REQUEST FOR ADDITIONAL INFORMATION - SSD 10437

This letter provides a response to the Request for Information (RFI) prepared by the Department of Planning, Industry and Environment (DPIE) dated 17 February 2021. This letter provides supplementary information for the assessment of SSD 10437 relating to the Waterloo Metro Quarter, Southern Precinct Over Station Development (OSD).

Elevation West

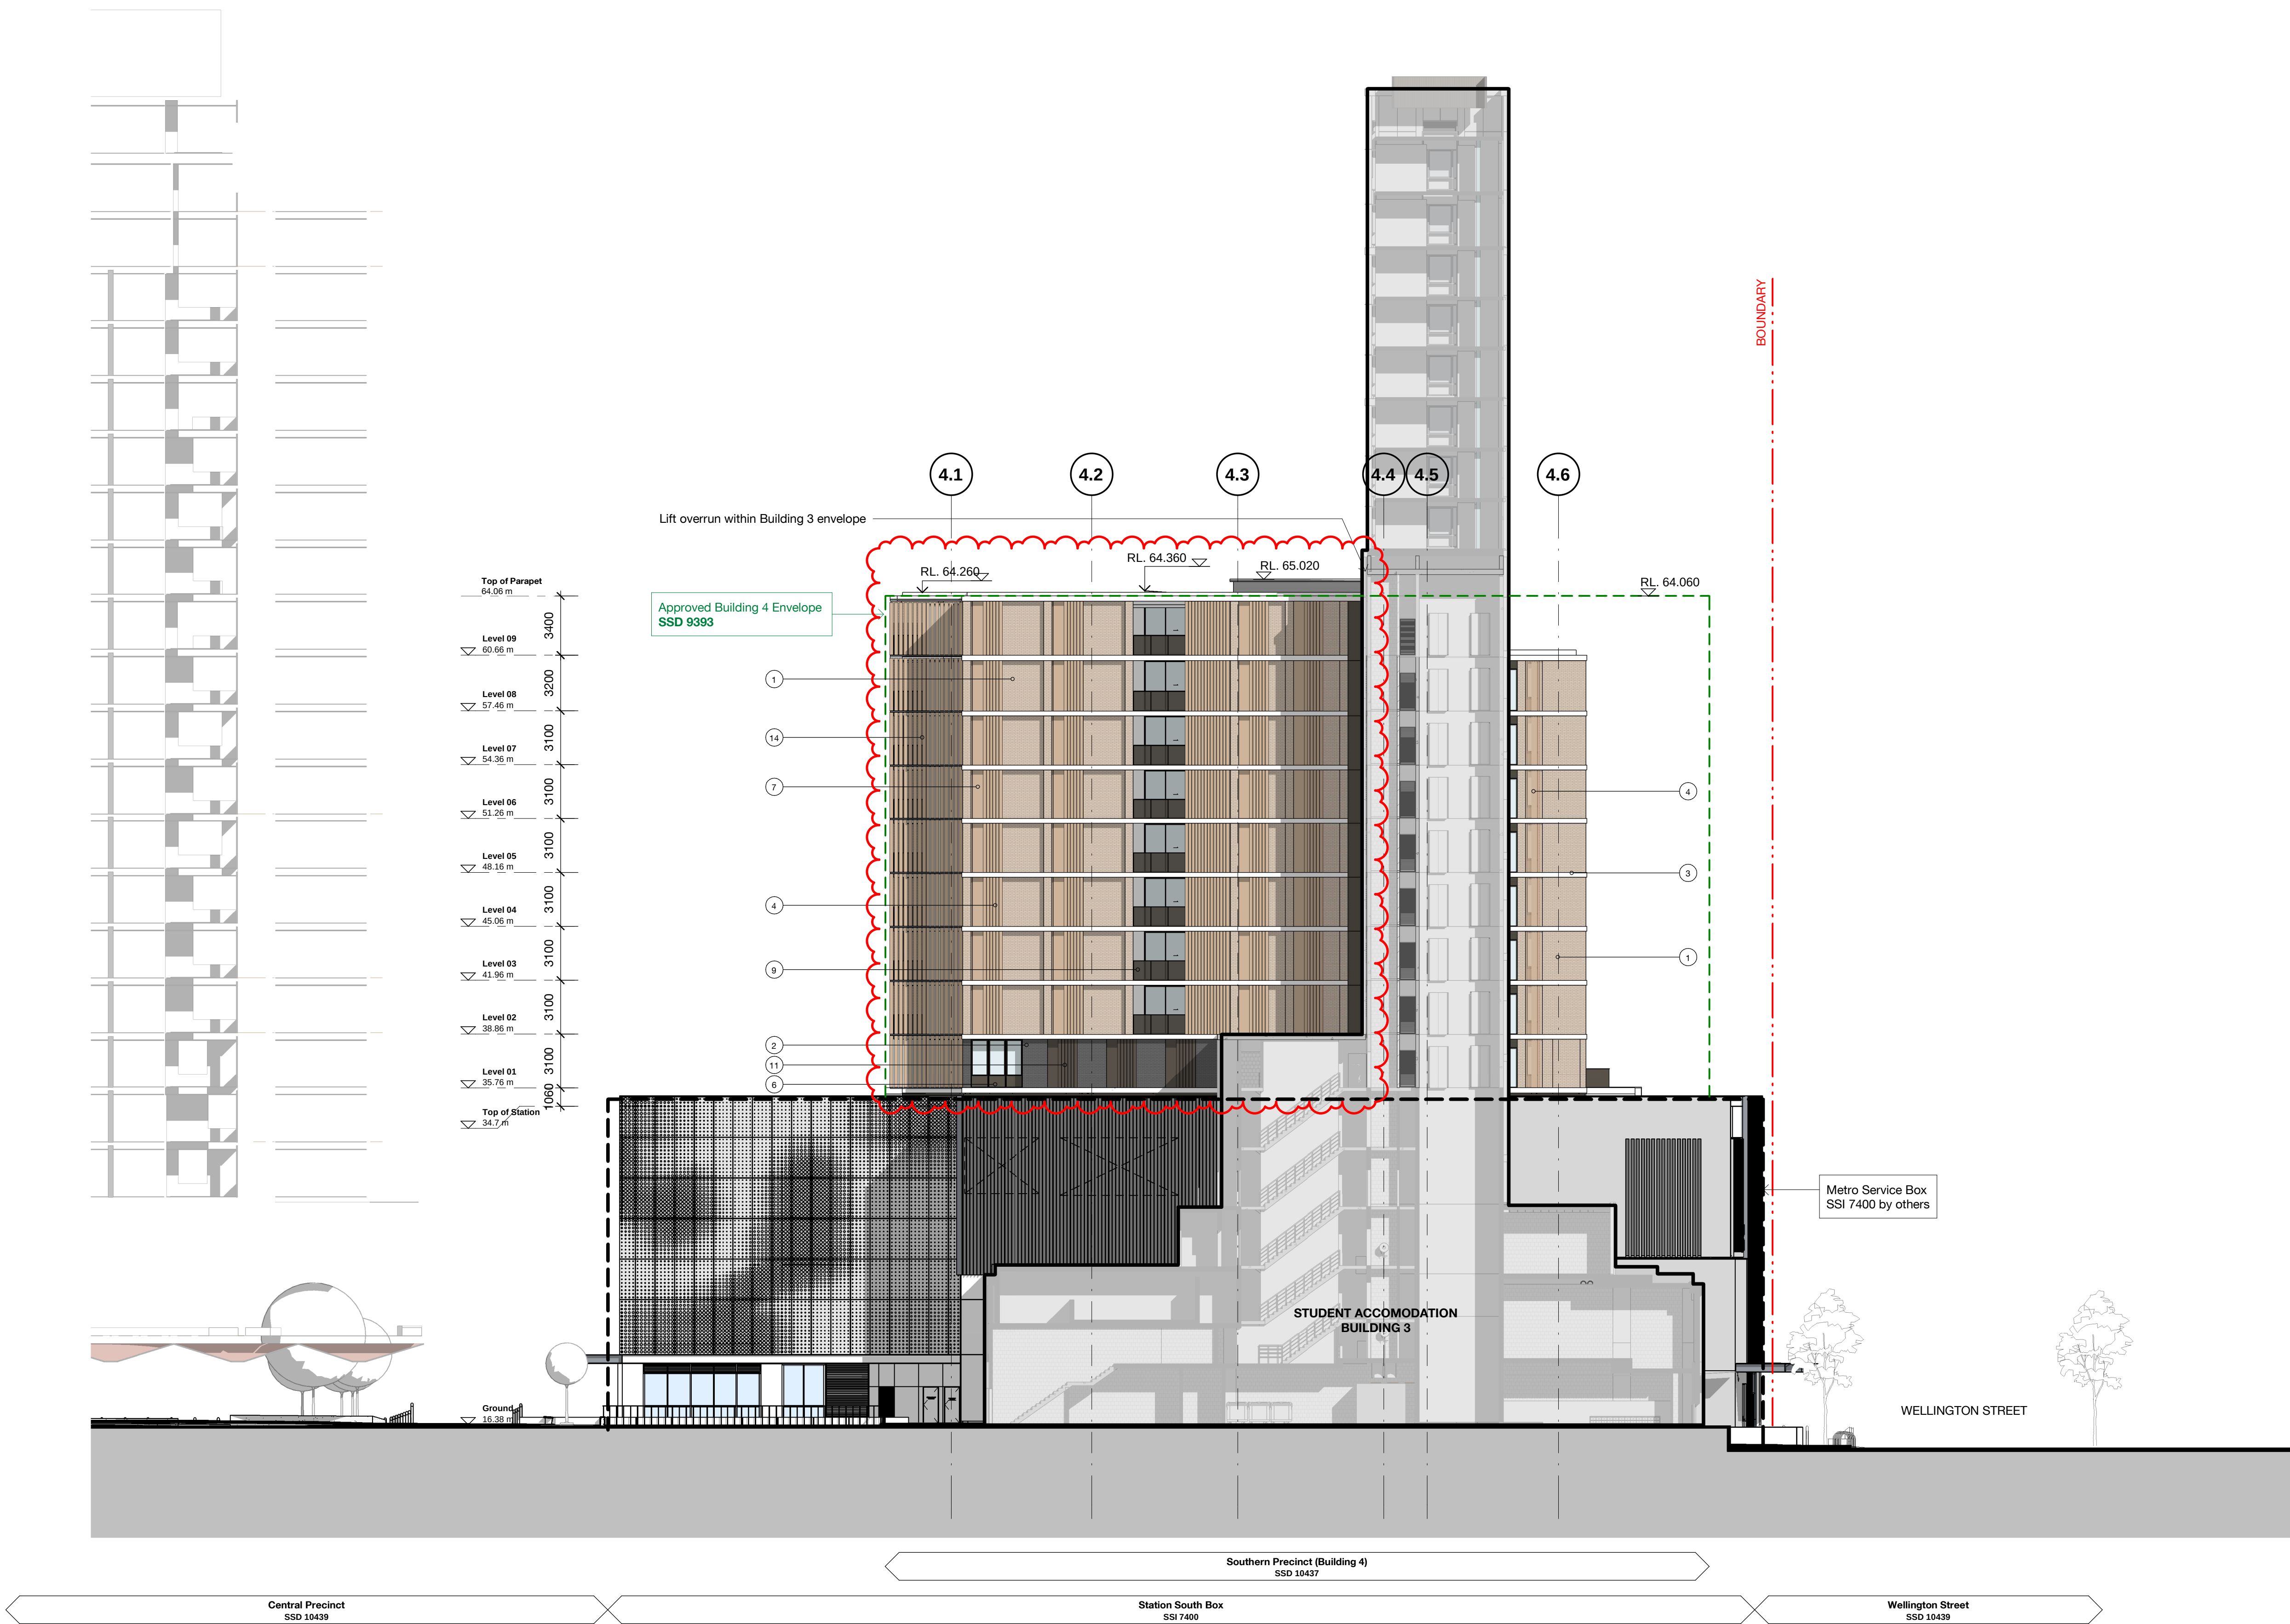
In response to the DRP comments, operable louvres were added to the western side of the Social Building. The louvers provide protection from the western sun and additional privacy screening for the Social Building, while rationalising the eastern side of the Student Building.

- Reconfiguration of services
- Addition of screened louvres to western façade of the Social Building in response to the DRP comments.
- Modification of glazing units to the southern façade through design development.
- Reconfiguration of Apartment Type 2B
- Addition of a safety rail on station roof

Sheet title
General Arrangement Plan
Level 3-5 Plan

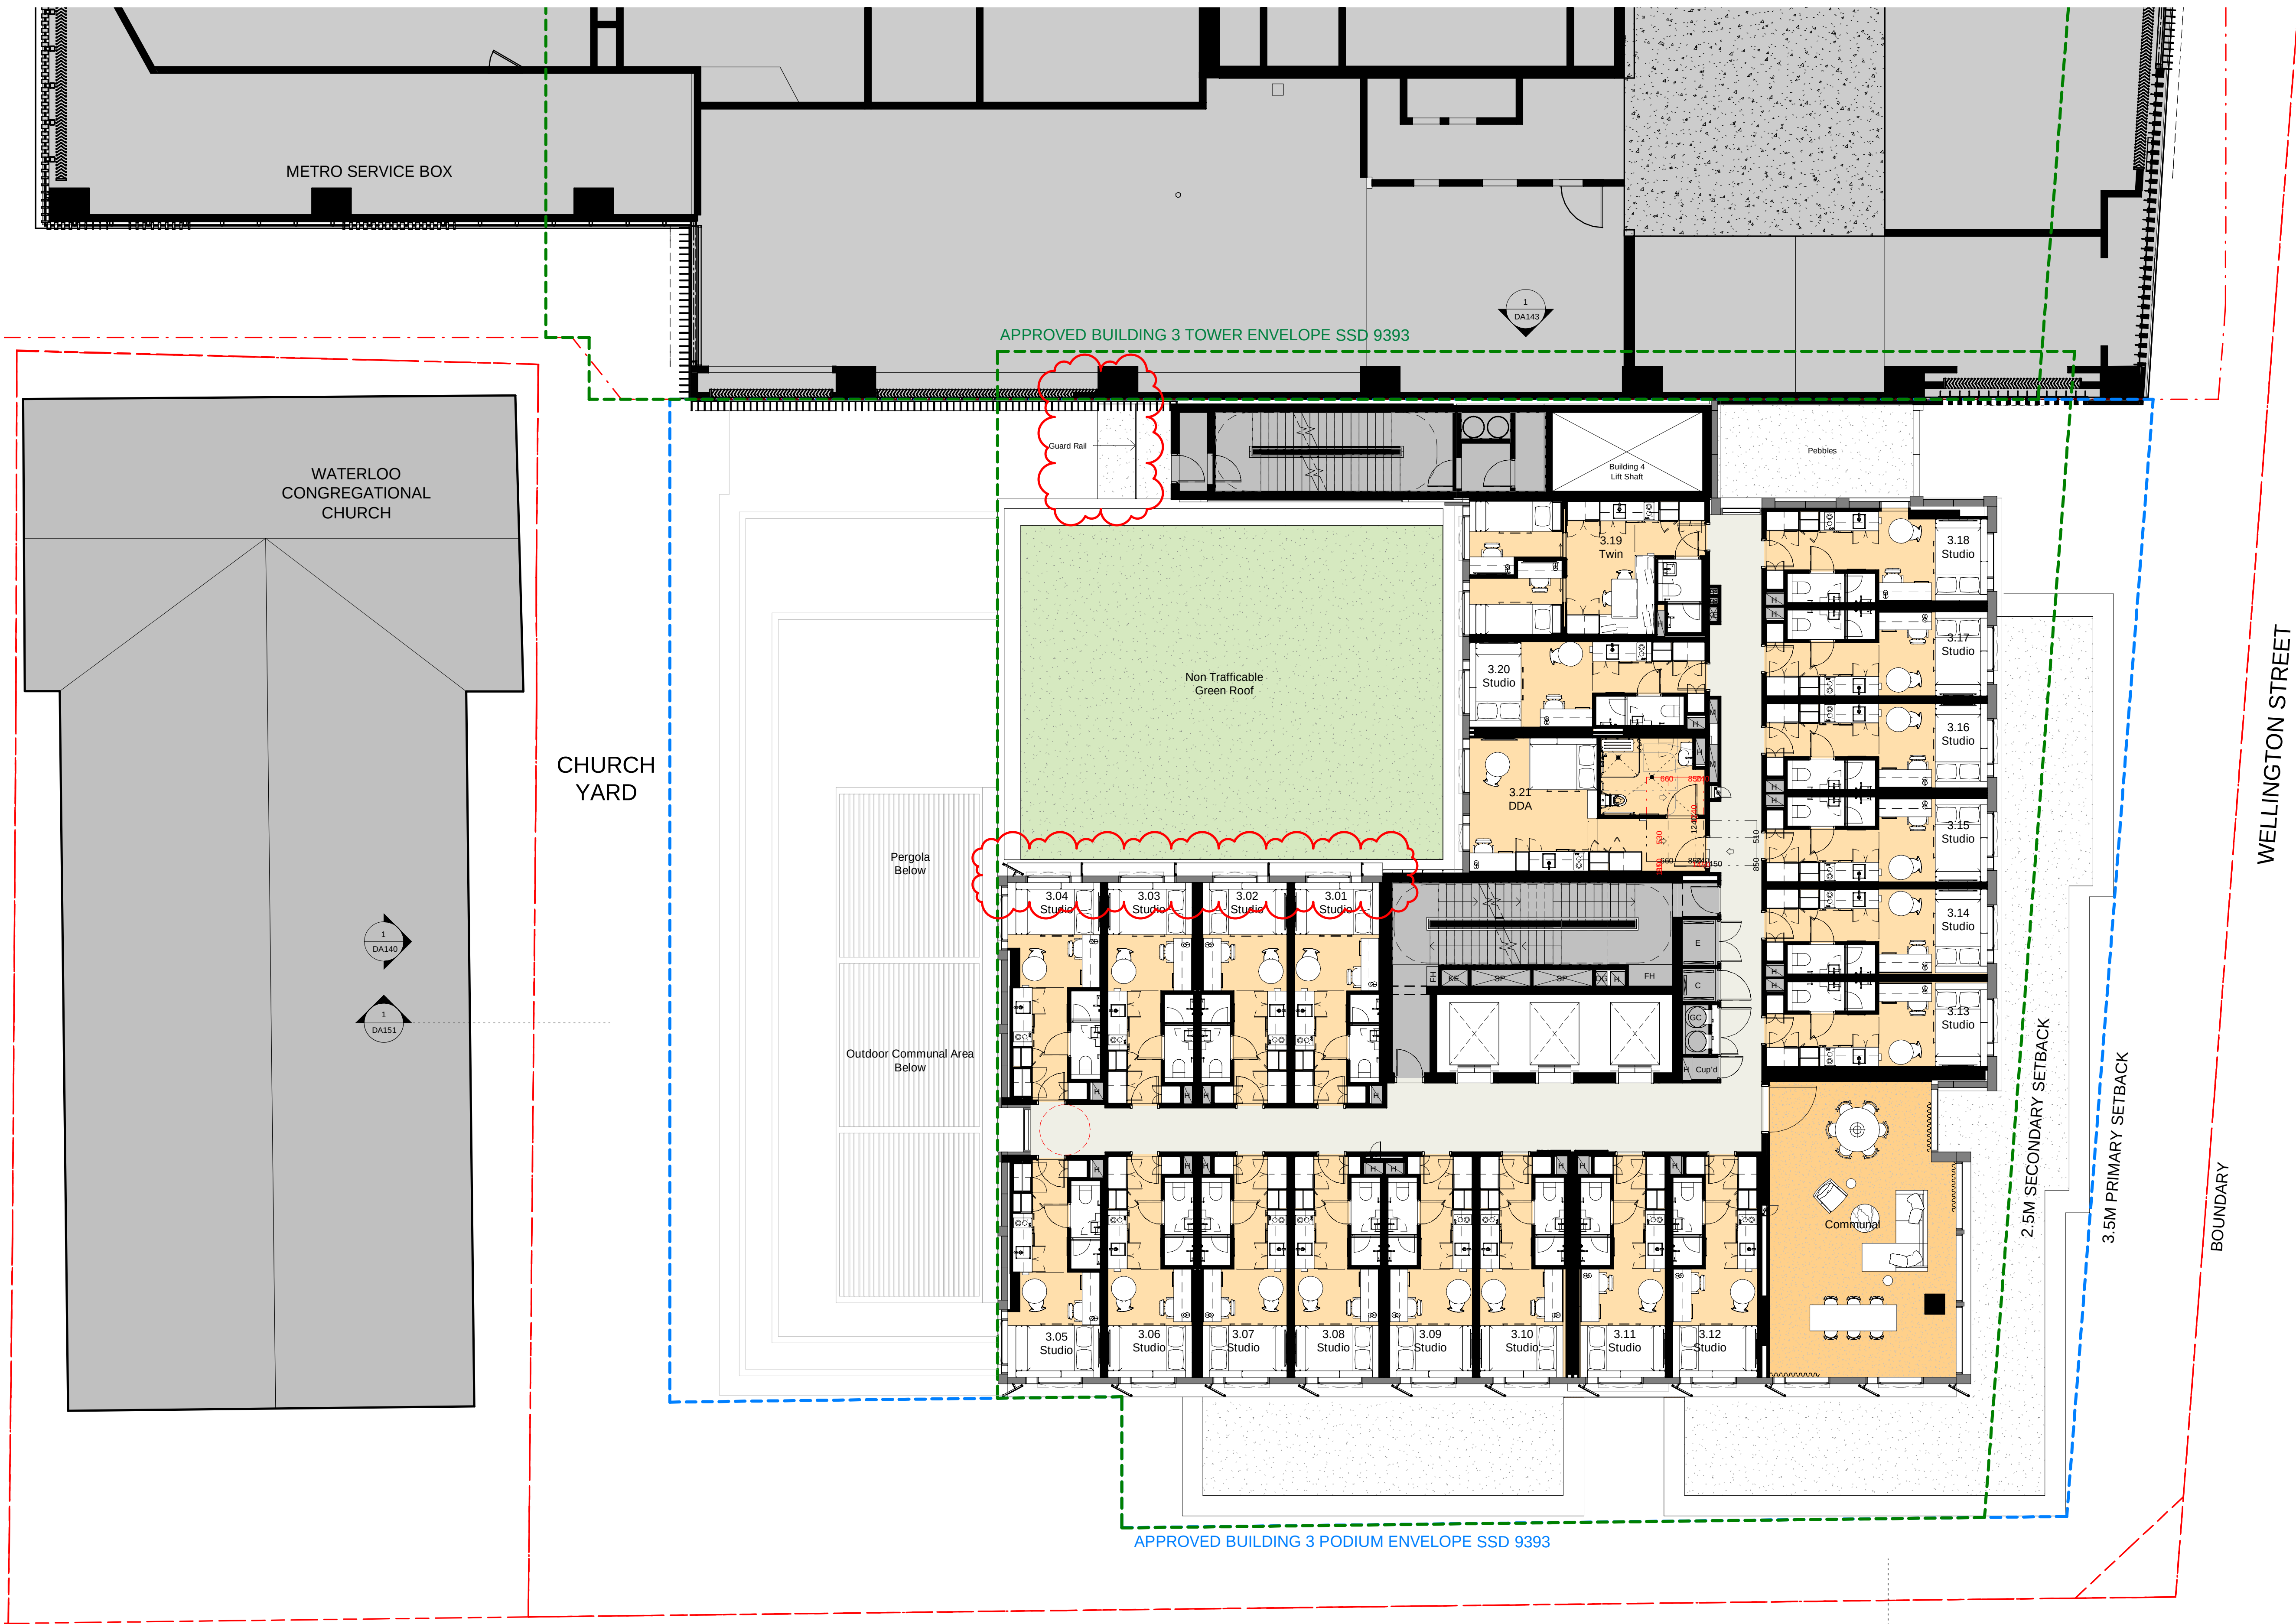
With regards to building separation and visual privacy impacts, the design amendments to the eastern façade of Building 3 and western facade of Building 4 include replacing the previously proposed sunshades with vertical sunshades to improve privacy and shading between residents of the student and social housing dwellings. These amendments have been reviewed by the DRP and are supported.

- Change to vertical blade on eastern façade in response to additional screening on western façade of Building 4
